Planning Officer: Mr A Wood

Planning Application Ref: FG/105/20/PL

Location: The Tudor Close Public House, Ferringham Lane, Ferring, BN12 5NQ

Description of works: Conversion of existing Public House (Use Class A4) to create 7 No residential units comprising 5 No 1-bedroom units & 2 No 2-bedroom units & the erection of 2 No 1-bedroom semi-detached bungalows, associated car parking & landscaping (resubmission following FG/46/20/PL). This application affects a Public Right of Way & is in CIL Zone 4, CIL Liable for new dwellings.

Dwg. No. **3932-C4**

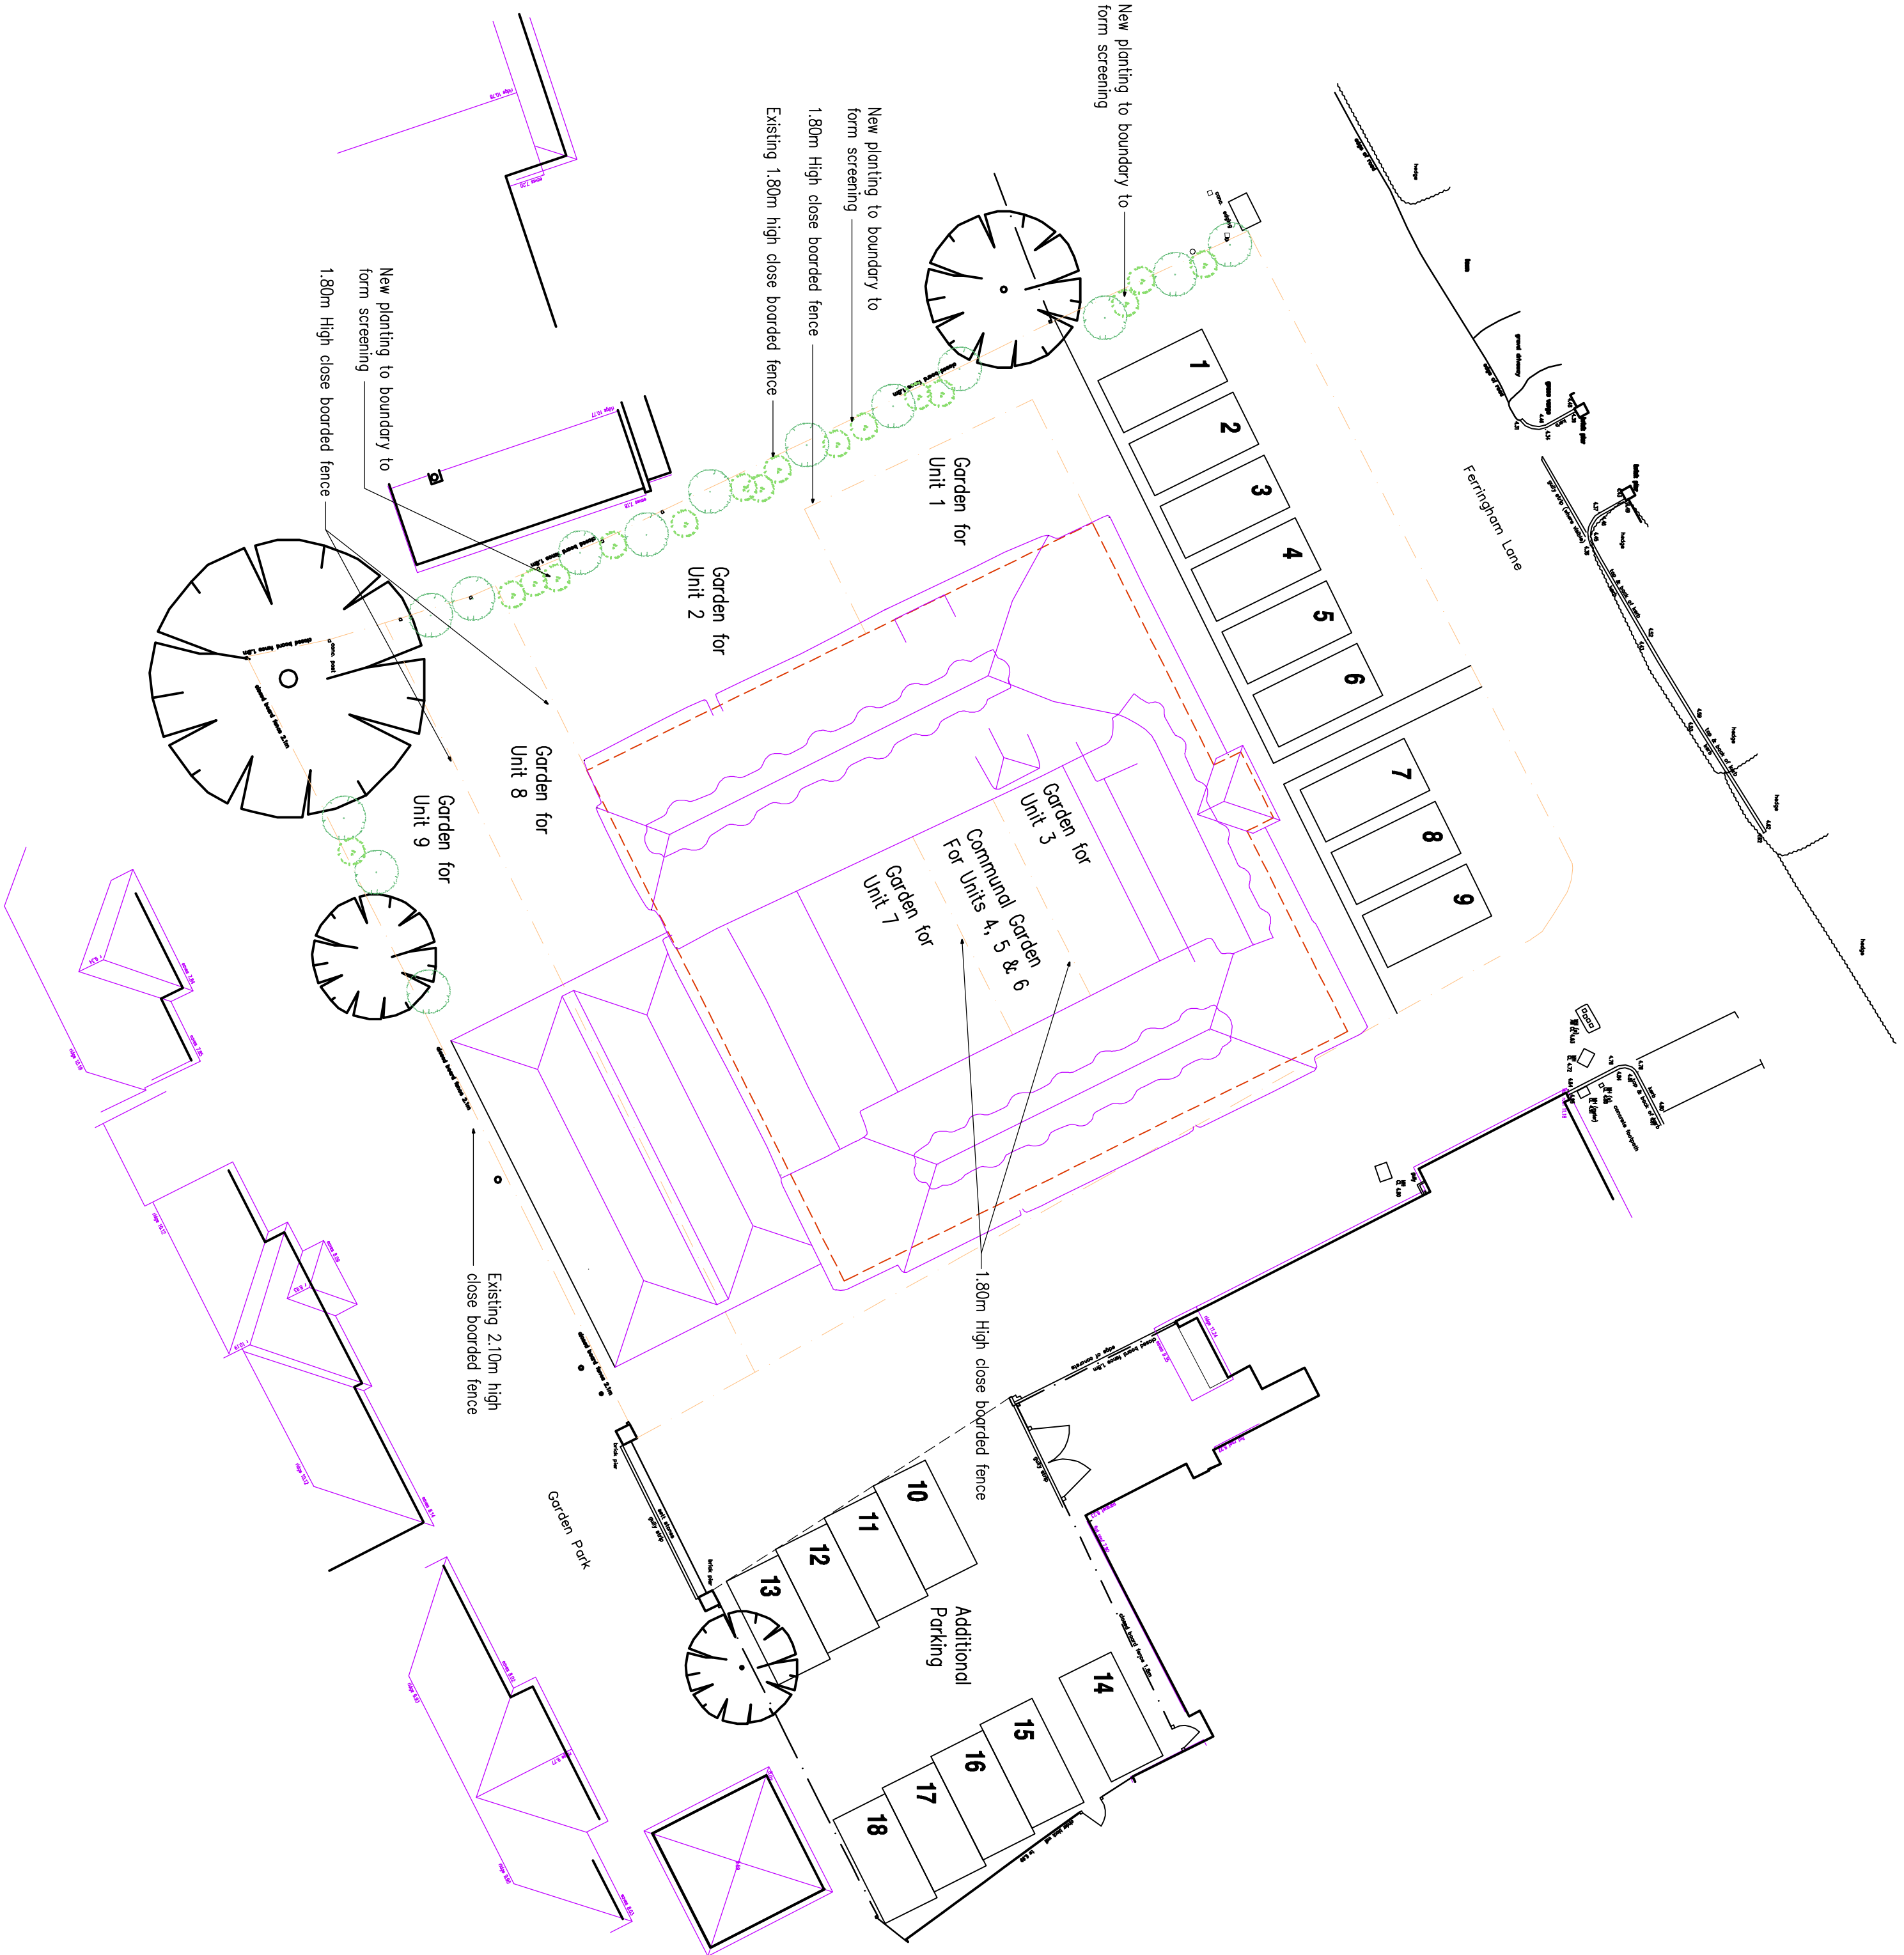
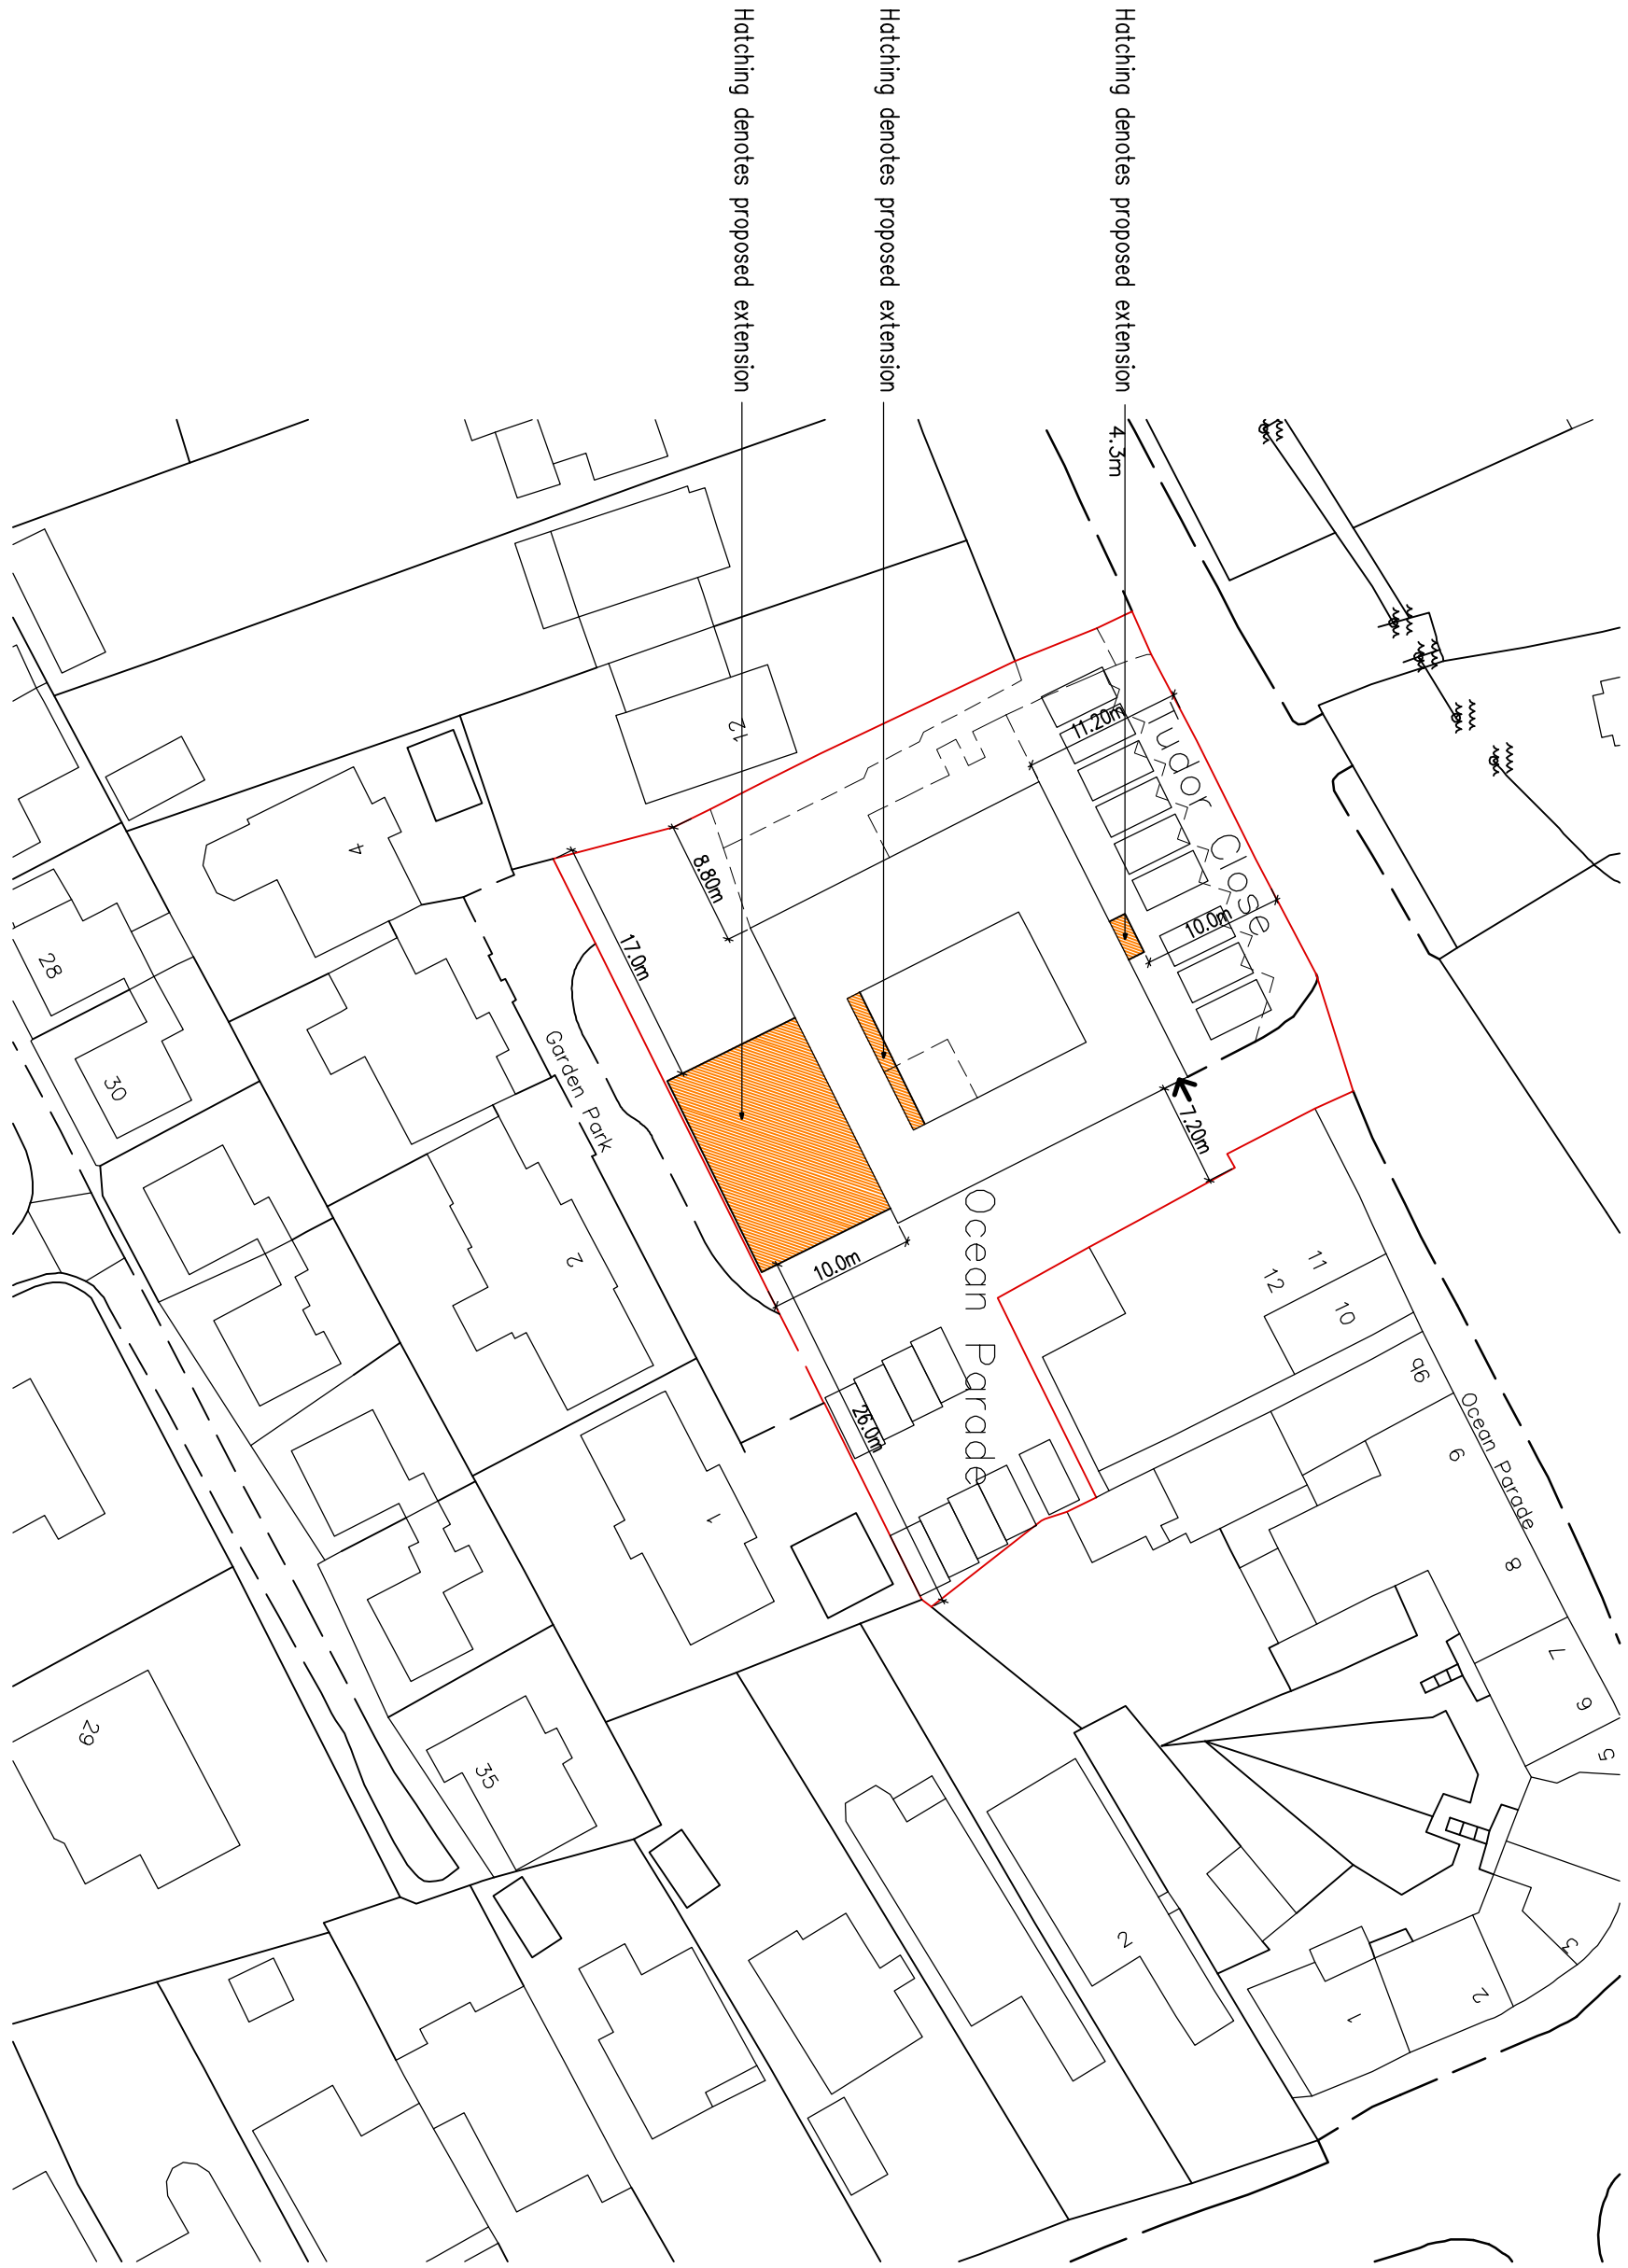
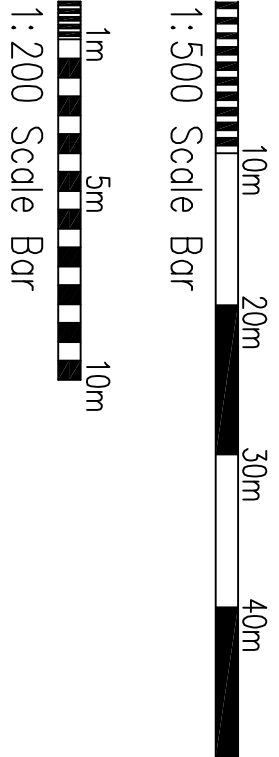
- I have read the supporting Design and Access Statement and studied the proposed Block and Landscape Plan, dwg. no. 3932-C4, Rev D. I am unsure if any treatment of existing hard surface within the nominal root protection area (RPA) of retained trees is proposed, so must assume there will be. Furthermore, if approved, the development will involve construction in proximity to those trees and involve installation (possibly including preparatory excavation) of 2m high close-boarded fencing within RPAs.

1. The applicants will need to employ the services of an Arboricultural Consultant to carry out a tree survey exercise and then prepare an Arboricultural Impact Assessment (AIA) which must be inclusive of; a 'Tree Survey Schedule', a 'Root Protection Area (RPA) Schedule' and a 'Tree Constraints Plan' – with the trees accurately plotted on same.
2. In the event that a RPA of any tree which is proposed for retention overlaps the development then BS5837:2012 requires that the Detailed Planning Application is accompanied by an Arboricultural Method Statement (AMS) and also most importantly a Tree Protection Plan – to both describe and illustrate the mitigation measures which are to be employed to ensure that the trees survive without detriment to their vigour and vitality and are given adequate protection both above and below ground.
